# Rezoning Transportation Analysis

Petition Number: 2020-019

General Location Identifier: Tax ID 11101102

Date	Description
03-25-2020	First Review

**RZ-1**

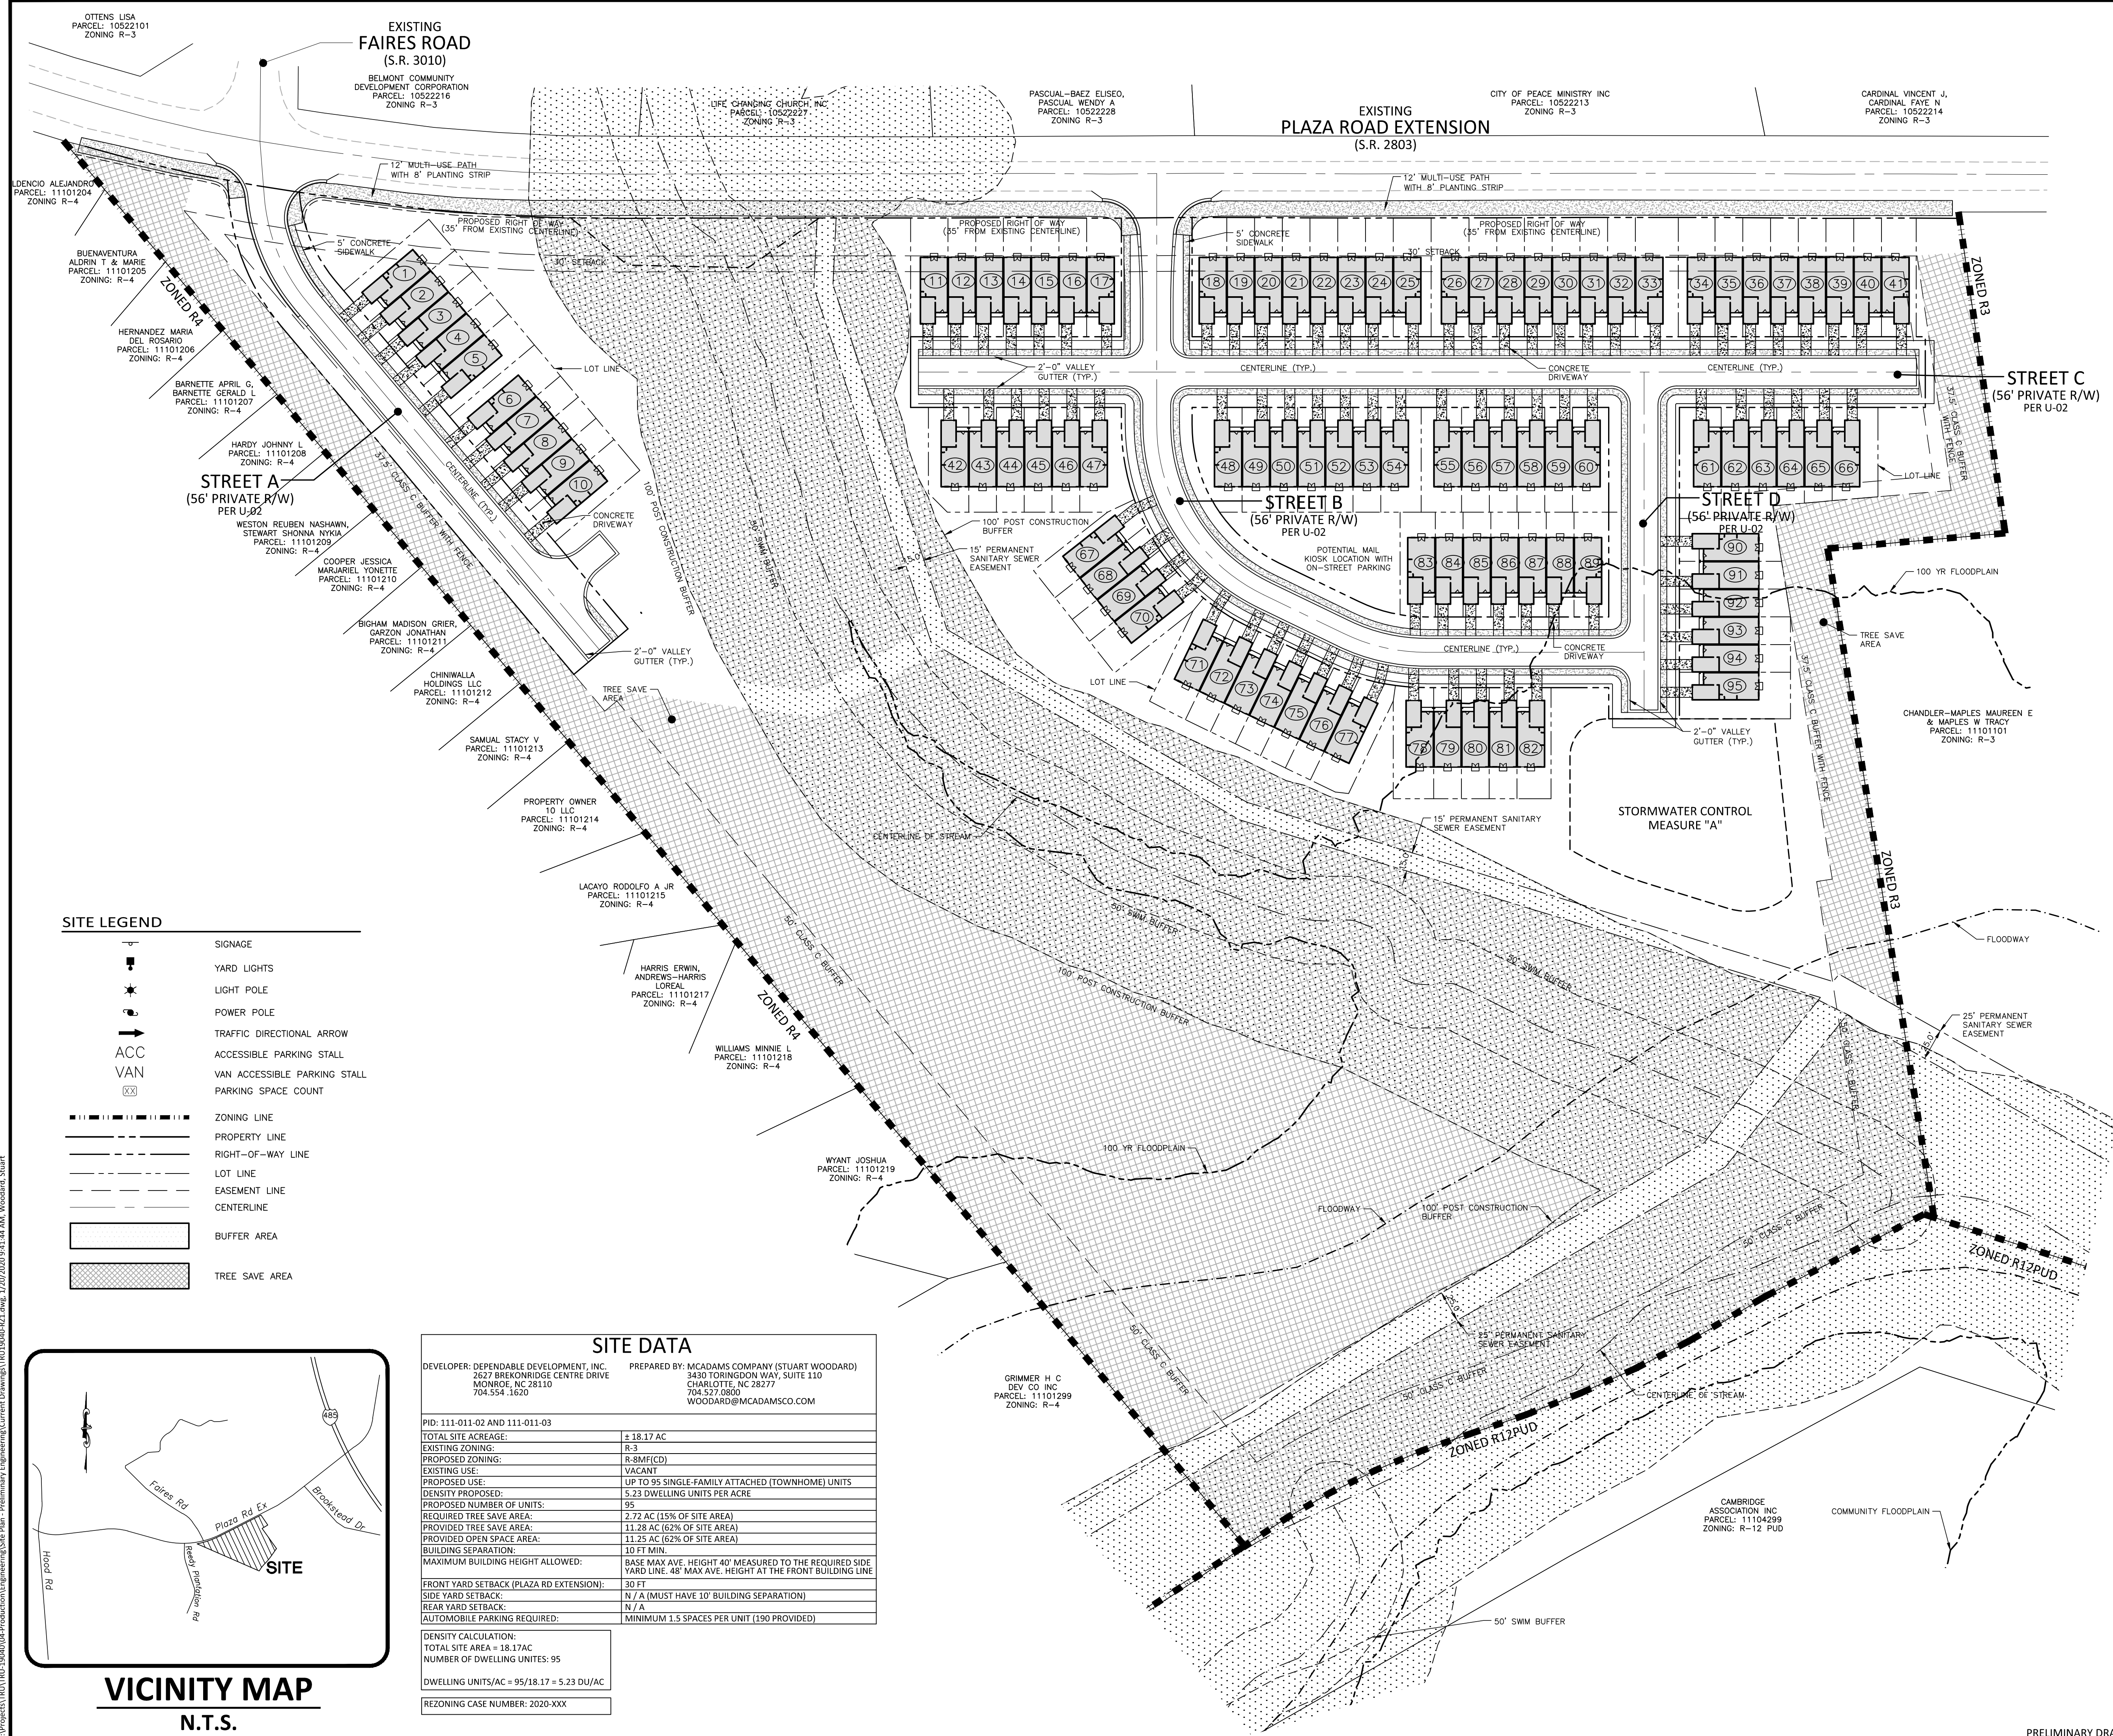
- a. **Plaza Road:** The future back-of-curb is 19' as measured from the street's existing centerline. Chapter 19<sup>th</sup> of Zoning Ordinance requires curb and gutter along thoroughfares. The petitioner shall revise the site plan and conditional note(s) to commit to construct the curb and gutter. The site plan should label and dimension the future curb and gutter from the centerline of the road. See note 3 for further details.
2. **Traffic Study** A Traffic Impact Study is not necessary for the complete review of this petition due to the site generation more than 2500 daily trips. If the during the permitting process the site generates more than 2500 daily trips, then a traffic study will be required.

3. The petitioner should revise the site plan and conditional note(s) to commit to dedicate 35' minimum right-of-way from the Plaza road centerline. The site plan should label and dimension the right-of-way for all public roads from the road centerline.

4. The petitioner should revise the site plan and conditional note(s) to commit to construct a left-turn lane with 150-feet of storage with appropriate tapers based on the posted speed limit for each access point on The Plaza.

5. The petitioner should revise the site plan and conditional note(s) to commit to construct a 3-lane section along The Plaza.
6. The petitioner should revise the site plan and conditional note(s) to commit to construct an 8-foot planting strip, and 5-foot sidewalk on all the Private Streets. The site plan should label and dimension both items

7. The petitioner should revise the site plan and conditional note(s) to commit to construct an 8-foot planting strip, and 6-foot sidewalk on Public Local Road C. The site plan should label and dimension both items.

8. The petitioner should revise the site plan to add a note specifying dedication and fee simple conveyance of all rights of way to the City before the site's first building certificate of occupancy is issued. CDOT requests right of way set at 2' behind back of sidewalk where feasible.

9. The petitioner should revise the site plan to add a note specifying all transportation improvements will be approved and constructed before the site's first building certificate of occupancy is issued. The petitioner may phase transportation improvements if said improvements and phasing are explicitly described in site plan notes.
